GG119 - F4 Road Safety Audit Decision Log
Prepared in response to Stage 1 Road Safety Audit by M
Planning Application 20233/91835 at location Cliff Hollin

Ieraki Alliance Ltd, dated 28/11/24
s Lane, East Bierley, BD12 7ET

| DRAWING NO:                                                                                | 2147 PL 126 (F)                                                                |       |          |

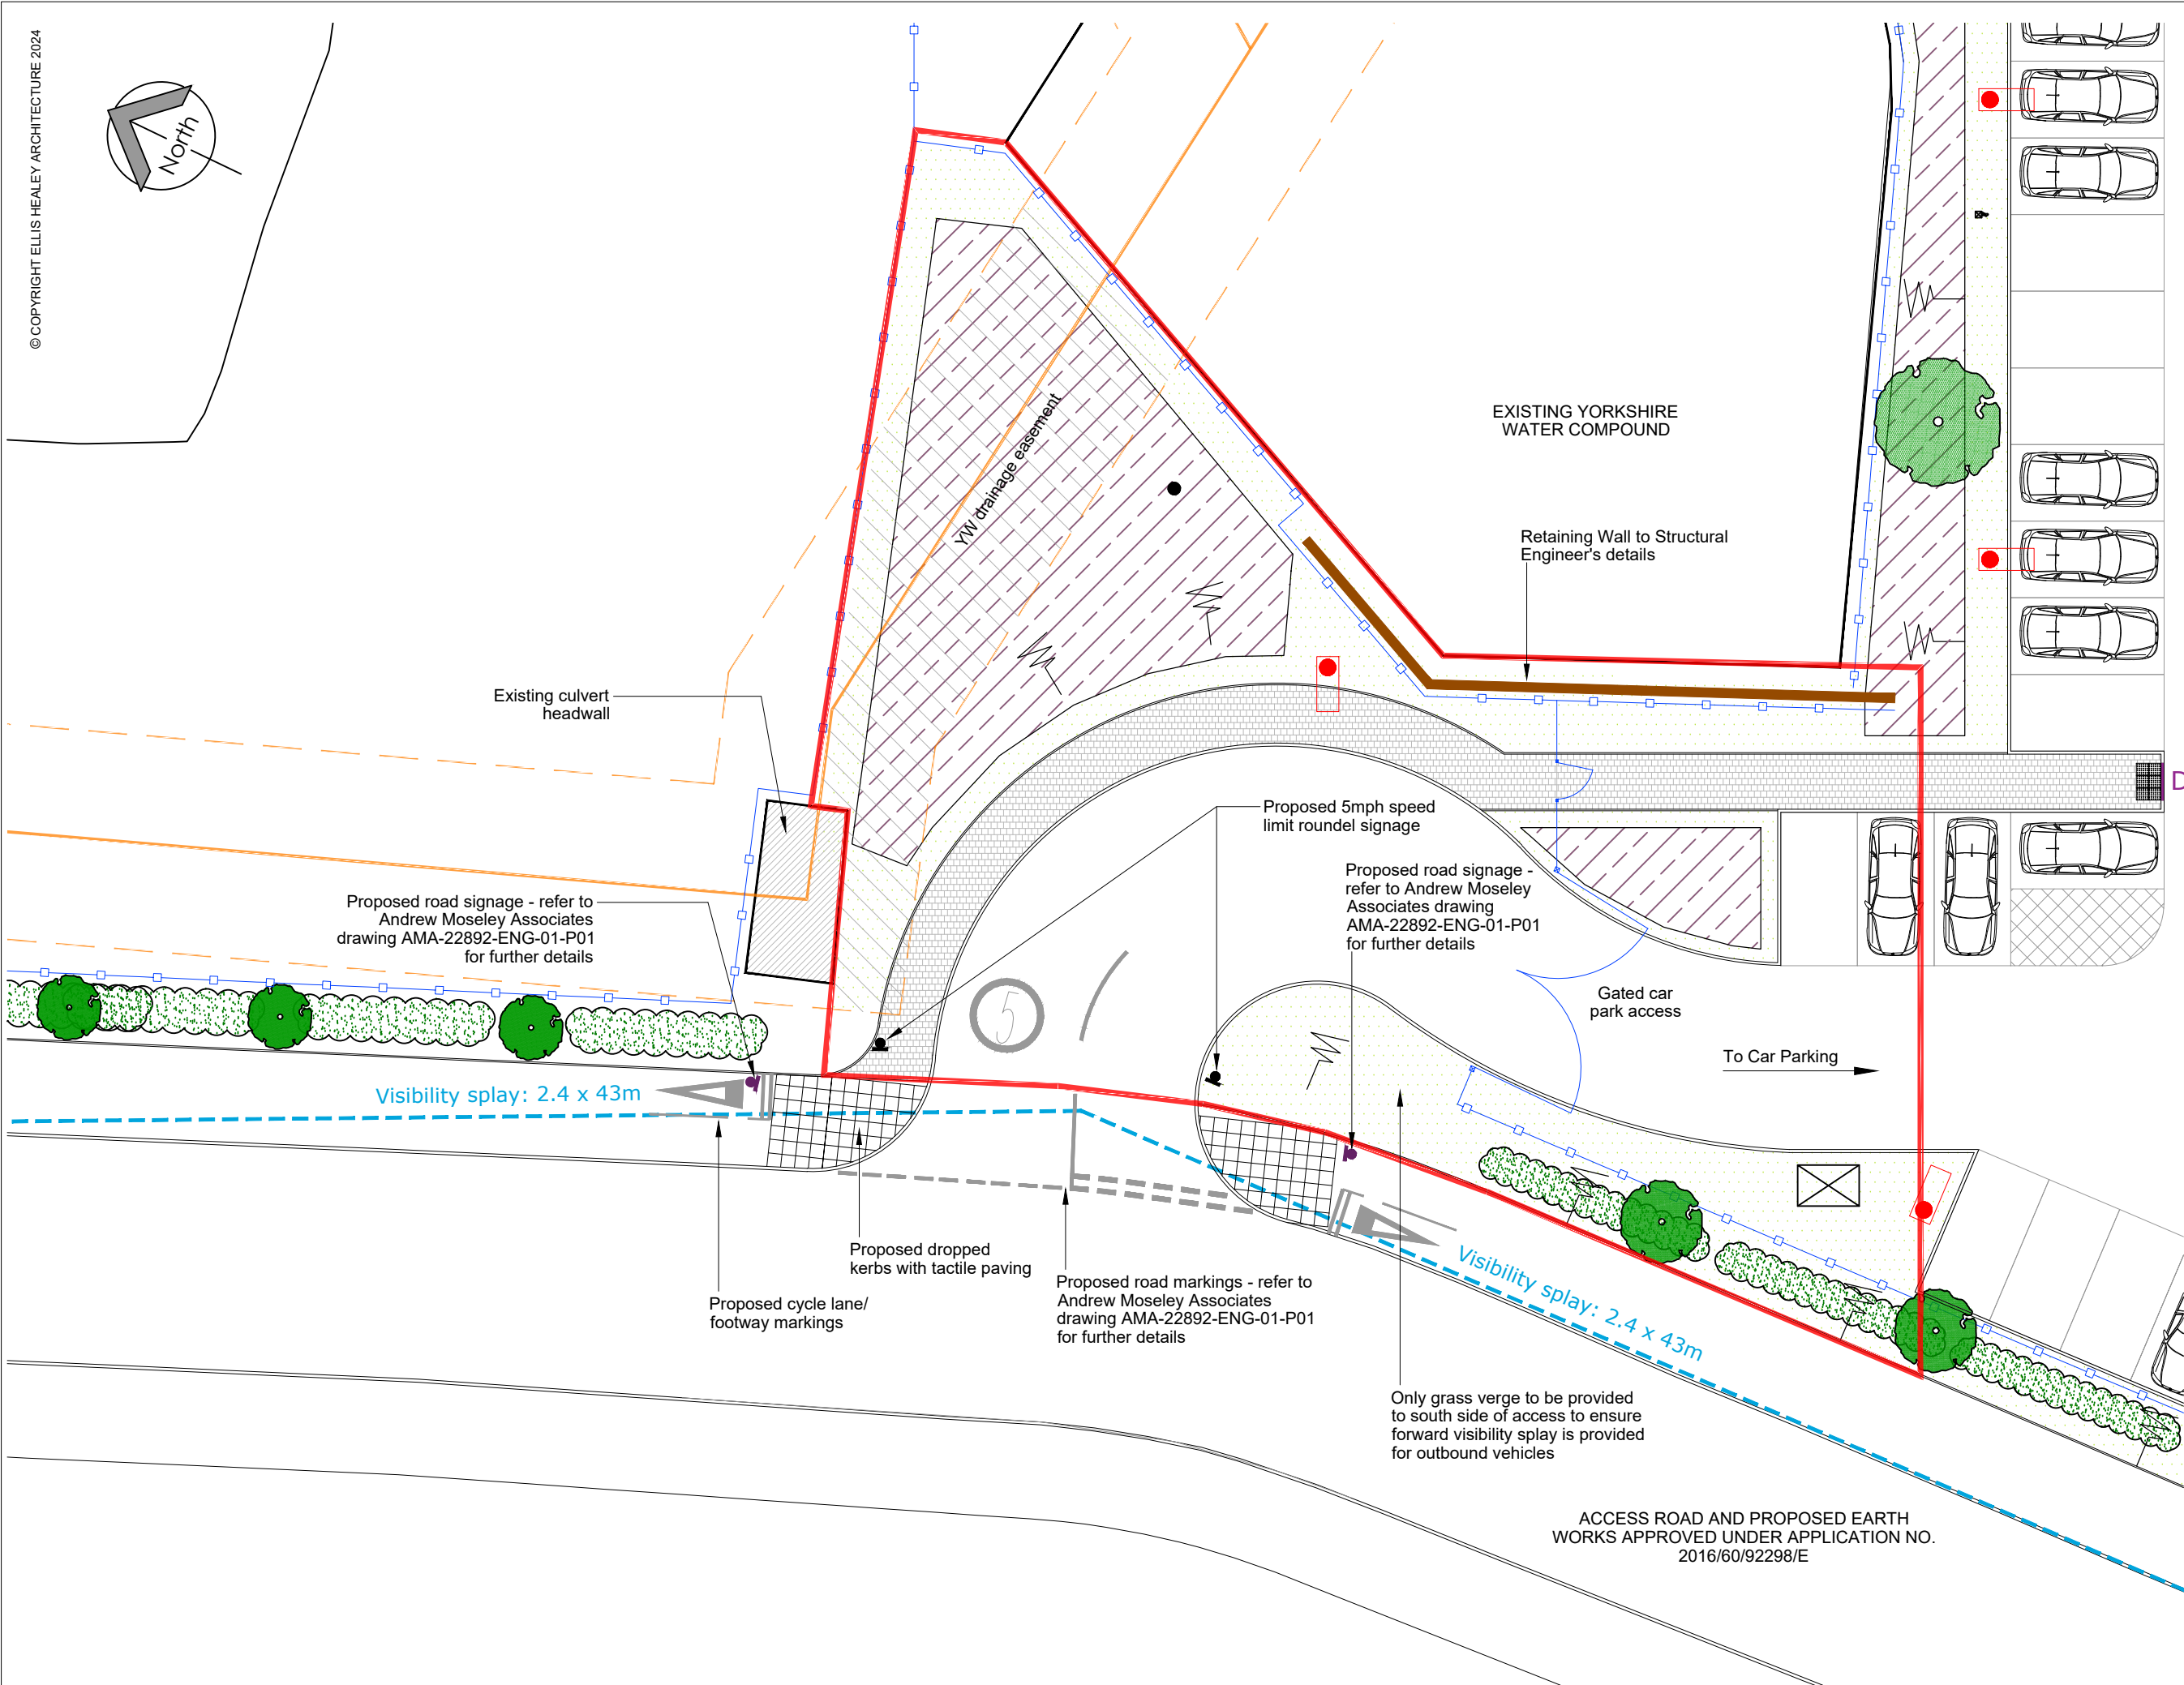
RSA Problem No	RSA Problem
Problem 1	During the site visit it was noted that the post and rail fence along the site frontage is incomplete. Also, the footway entering the site runs along an embankment. The drawings do not show if the post and rail fence will be completed and does not show any fencing along the footway to protect pedestrians from the embankment. A lack of suitable fencing will increase both the risk of pedestrians and cyclists falling down unprotected embankments.

RSA Recommendation	Design Organisation Response
Provide appropriate fencing both along the site frontage and the access road.	Appropriate fencing will be added to the architects drawings.

Overseeing Organisation Response	Agreed RSA Action
1.2m High fencing should be provided adjacent to pedestrian/cycle route along the site frontage. This should be identified on the AMA site access plans (and also the architects plans). For the footway on the outside of the bend on entry to the site, a similar fence should be provided, and identified on the architects site plans.	Provide 1.2m high fencing over a distance of 10m at either side of the site access.
